Submission on the NorthConnex EIS (Environmental Impact Statement).

**Department of Planning and Environment, Major Project Assessment, Attn:
Assessing Officer, Application No SSI136136, GPO Box 39 Sydney 2001 or
www.majorprojects.planning.nsw.gov.au**

MOTORWAY OPERATIONS COMPLEX - SOUTHERN VENTILATION FACILITY - SECTIONS
M1-M2-5000-DR-JD-0525

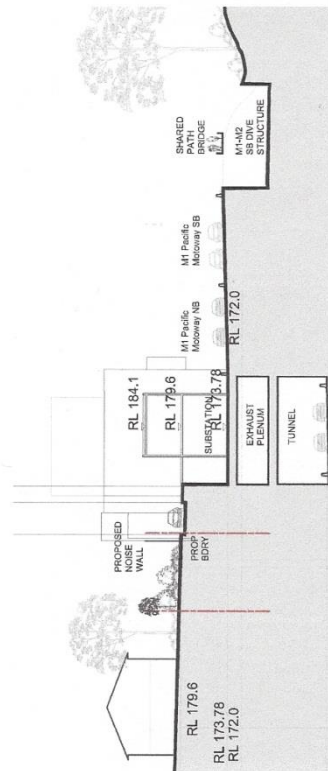
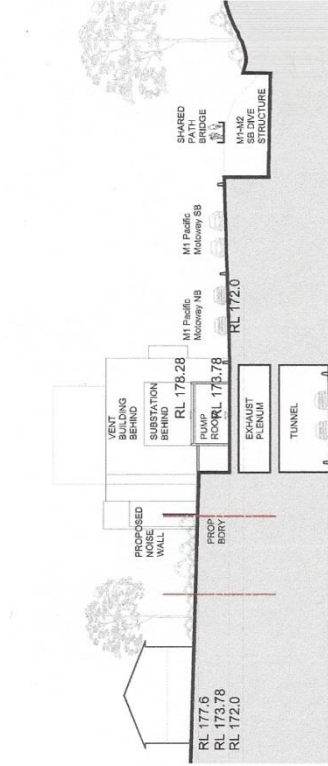
- The tunnel, 9km long, will not be filtered. Particles under 1 micron from diesel fumes are carcinogenic (cancer causing) and called the 'new asbestos' because their impacts take a long time to manifest. Concentrated emissions will come from the unfiltered stacks at the southern (near Pennant Hills Golf Club) and northern end (Wahroonga) and drift onto nearby residences and schools endangering the long term health of the community. Children are particularly vulnerable as they are growing. These stacks must be filtered.
